H2Teesside DCO Examination

South Tees Group (20049389) – Deadline 3 Submissions

Response to Deadline 2 Submissions

APPENDIX 1: MAP OF INDICIATIVE LOCATIONS EXCEEDING ORDER WIDTH

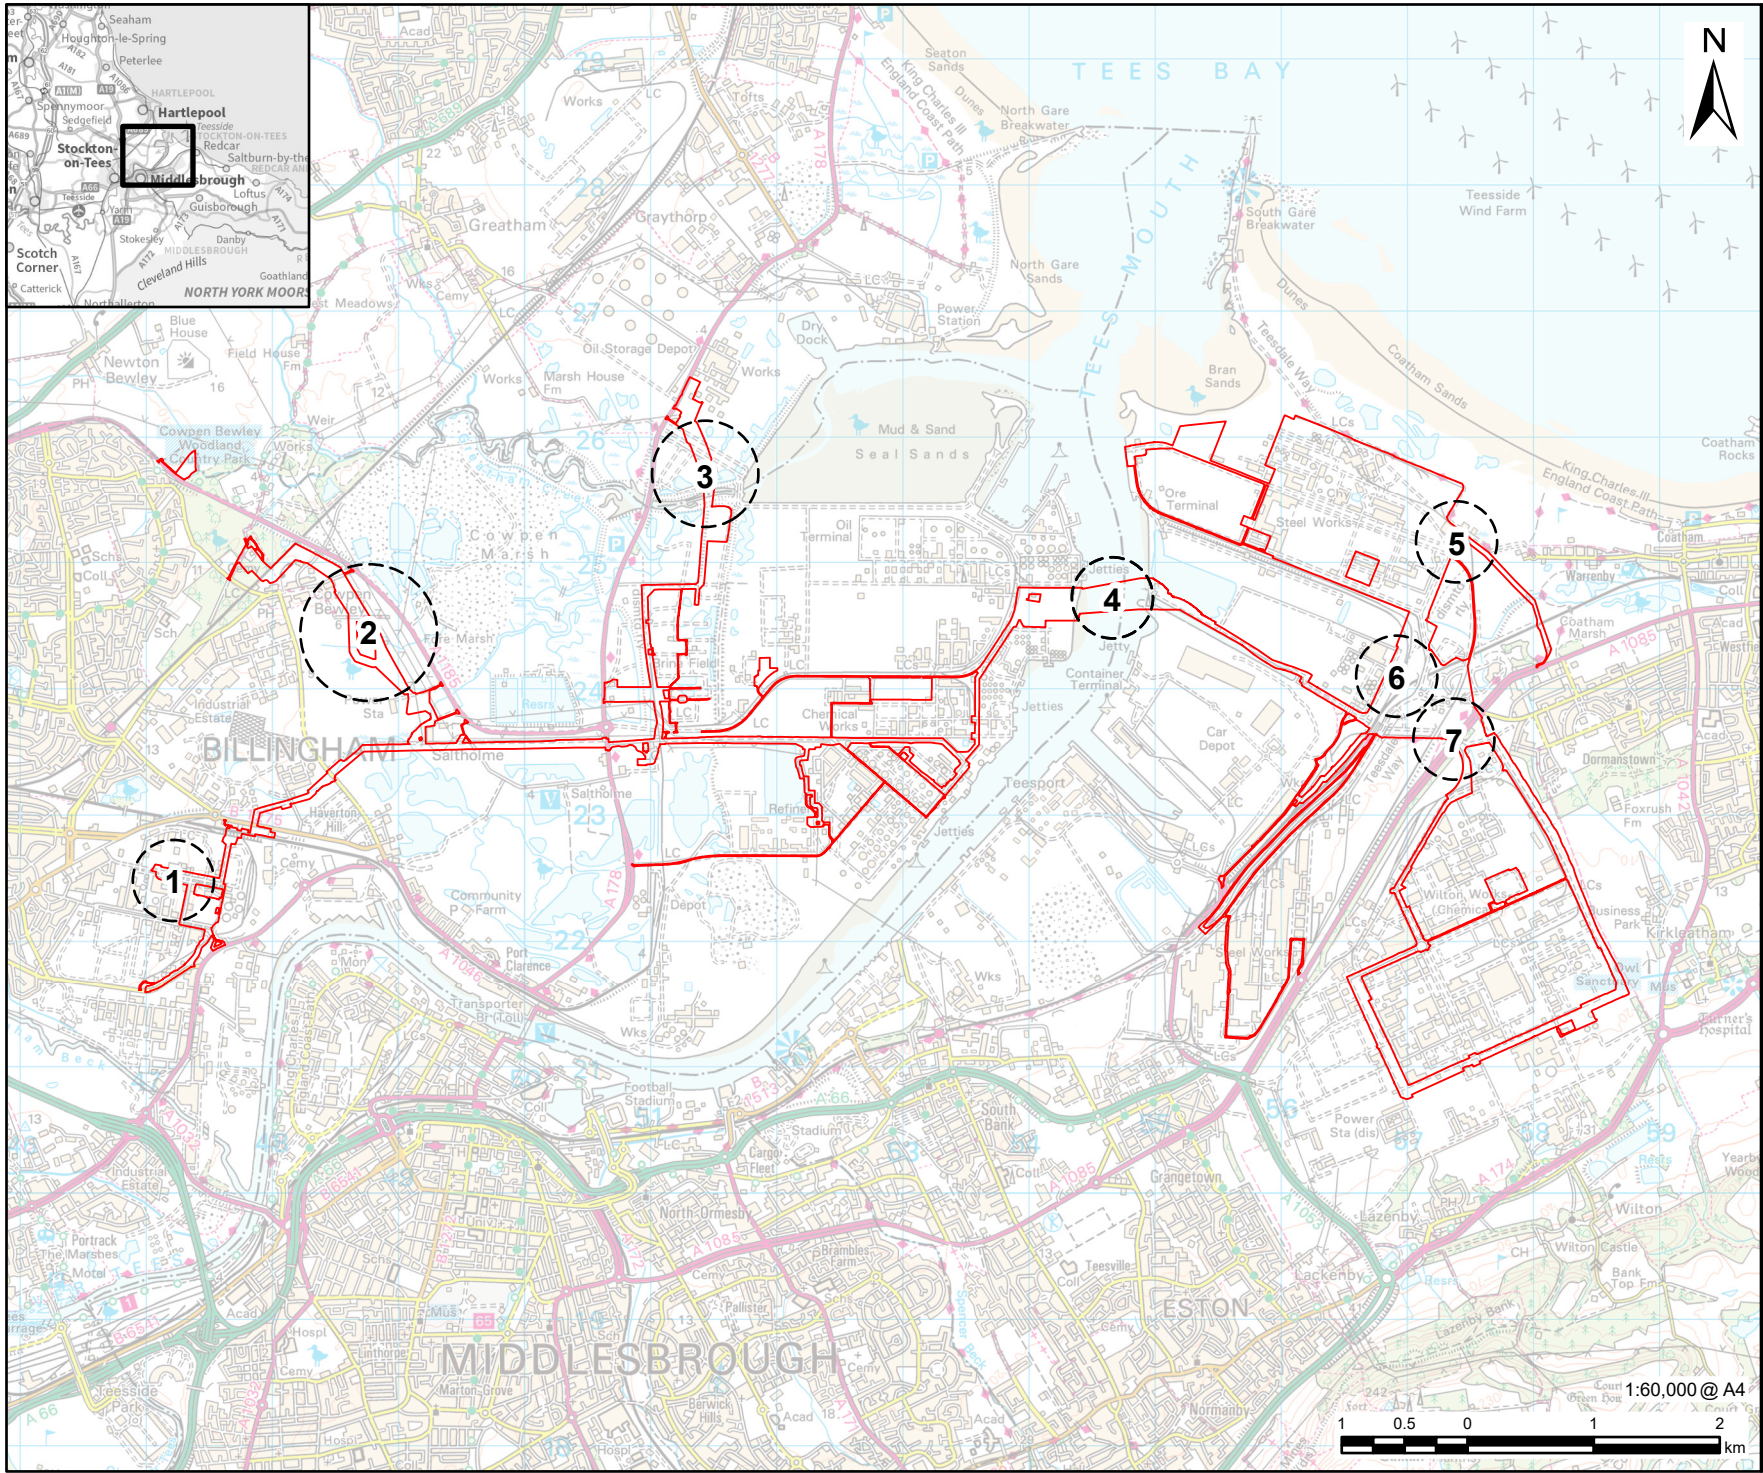
- 4.1 STG notes that the Order Width Limit explanatory note discusses the development of connection corridors – except for water, which is the only corridor on which STG responded at ExQ1.2.10 [\[REP2-110\]](#). STG therefore awaits the Applicant's direct response to its water corridors comment.
- 4.2 Additionally, the explanatory note expressly excludes the main site, temporary construction compounds and above-ground installations, so the Order Width Limits are only considered in areas around the main Teesworks site perimeter.
- 4.3 As the current document does not speak to STG's main interests and concerns, STG requests that the Applicant provide equivalent information for the main Teesworks site and water corridors before the November hearings, ideally in the form of a further version of the Deadline 2 document.
